Our Ref: LM/ARU/26/01A

Date 12th January 2026

RE: Phase 6A Hampton Park Littlehampton

Miss Lee A Melbourne
Designing Out Crime Officer
Local Policing Service Improvement & Engagement Department
Sussex Police Headquarters

drawing: Play Area LAP 1

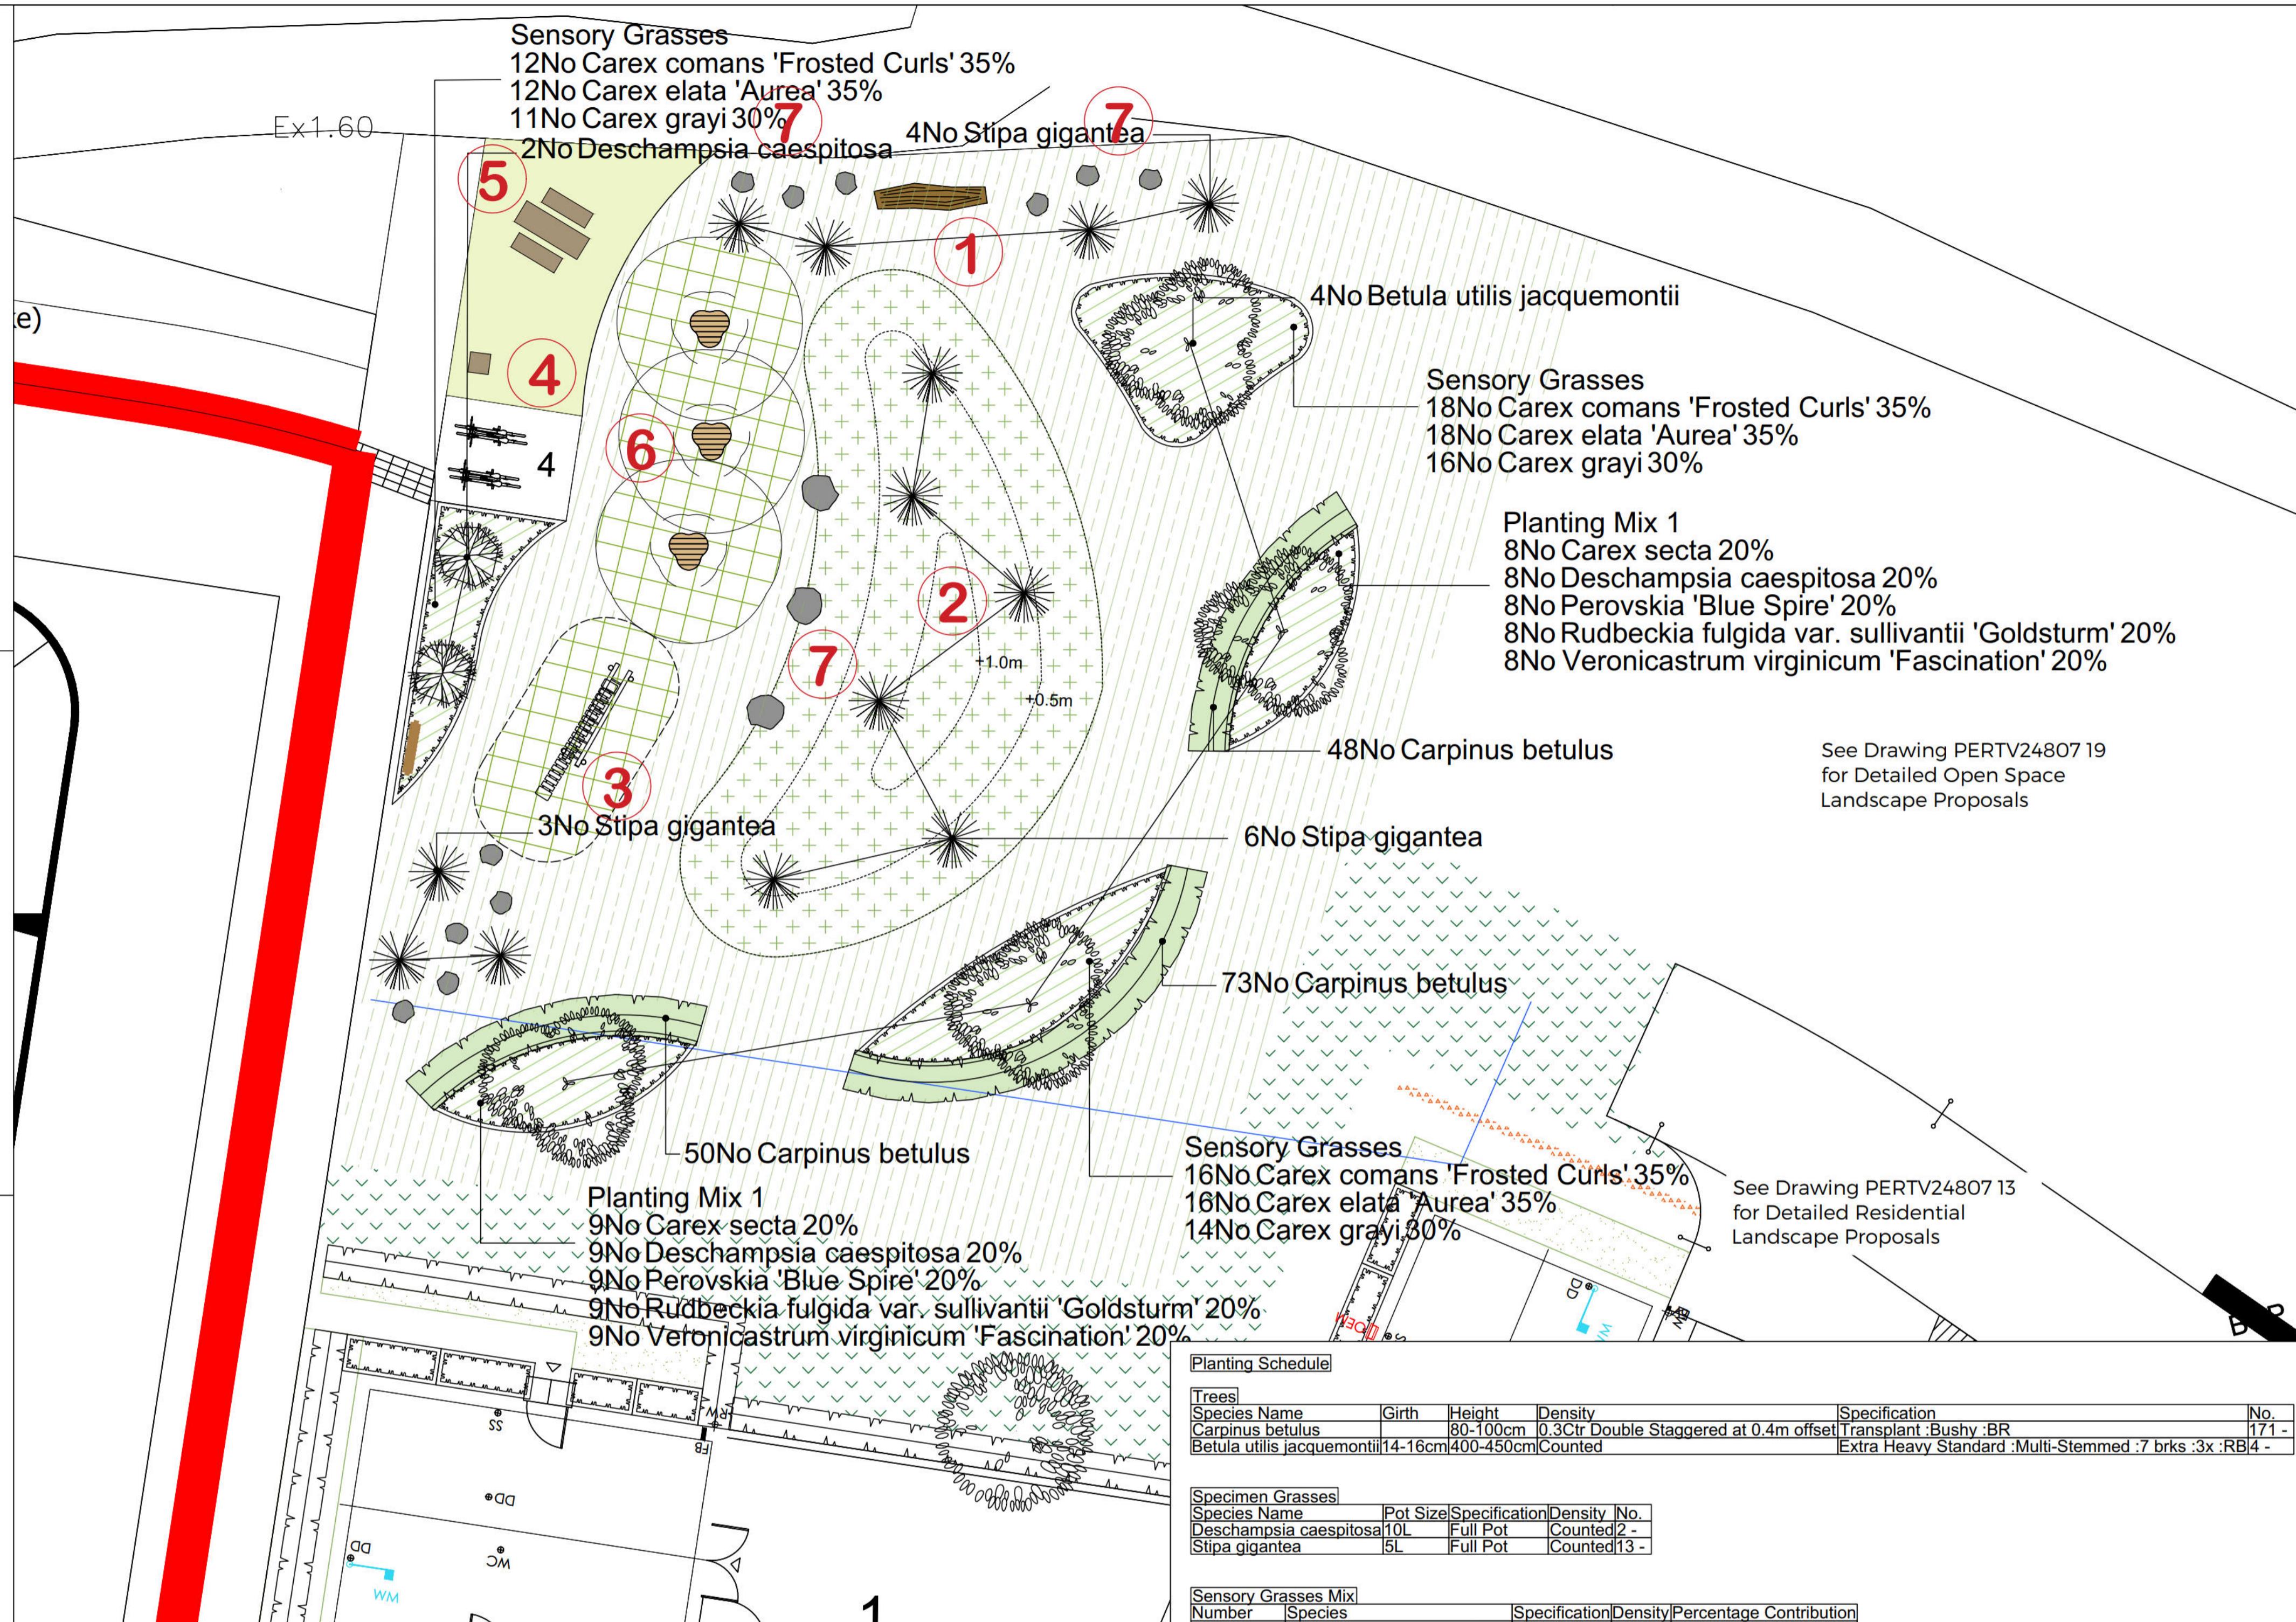
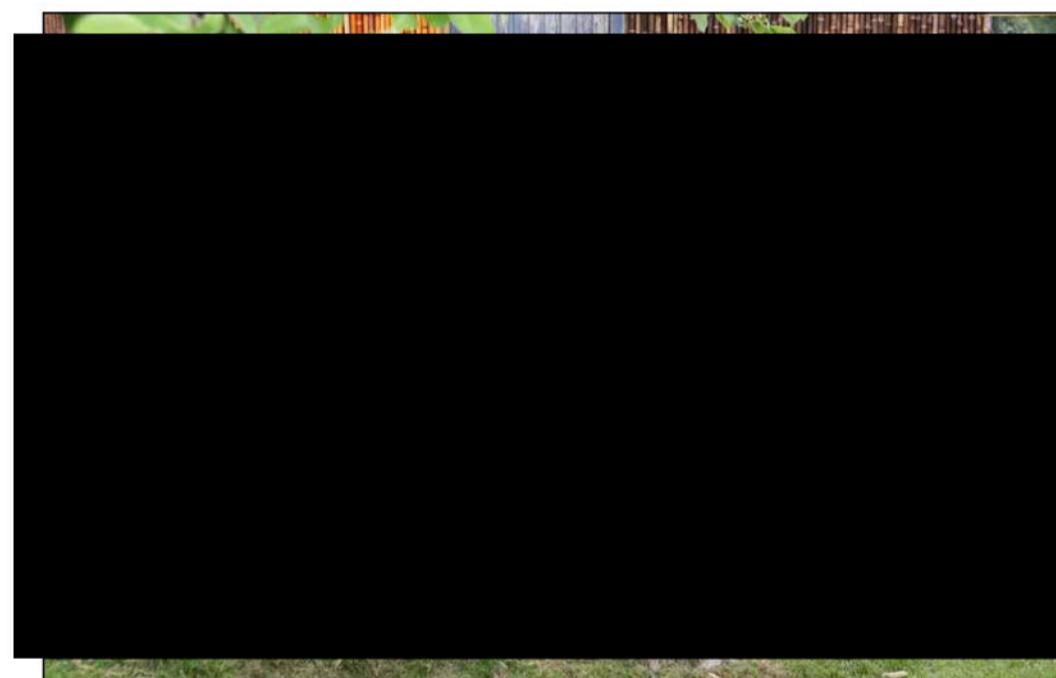
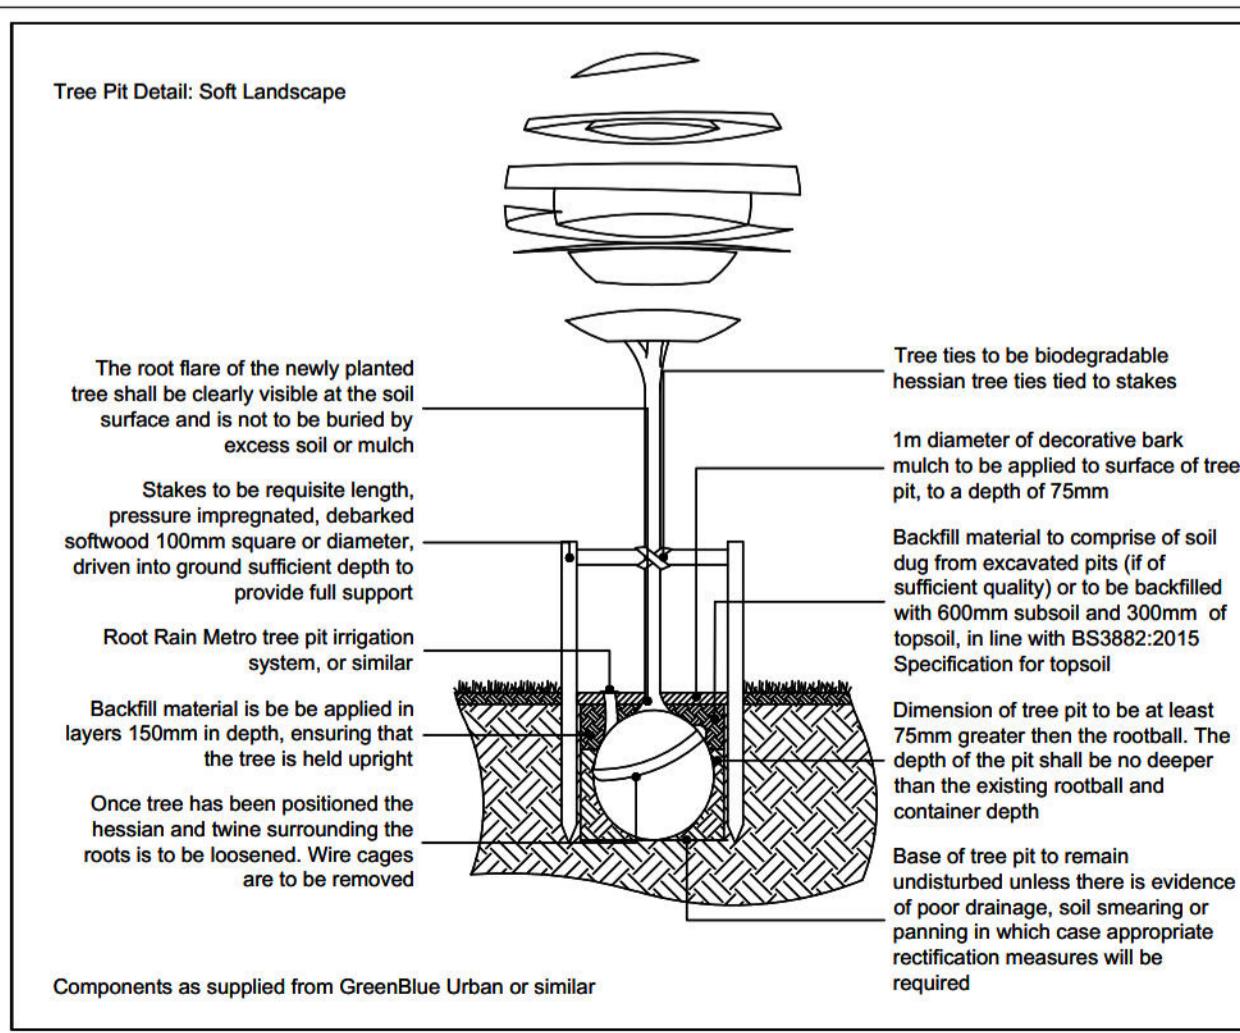
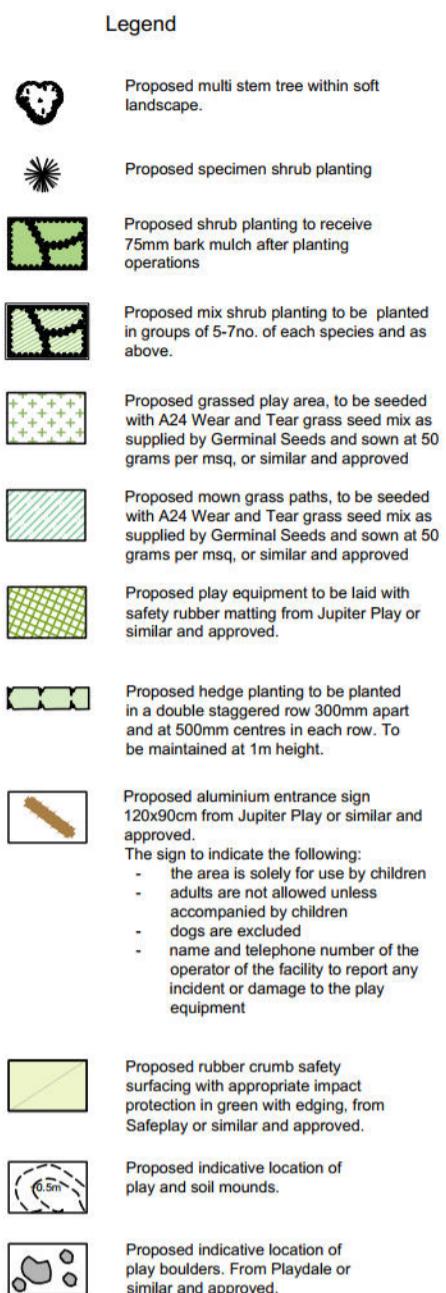
Areas of play should be situated in an environment that is stimulating and safe for all children, be overlooked with good natural surveillance to ensure the safety of users and the protection of equipment, which can be vulnerable to misuse.

They should be designed to allow natural surveillance from nearby dwellings with safe and accessible routes for users to come and go. Boundaries between public and private space should be clearly defined and open spaces must have features which prevent unauthorised vehicular access.

To provide a dog free environment for the proposed LEAPS - I would ask that consideration is given to surrounding the play areas with railings and self-closing gates.
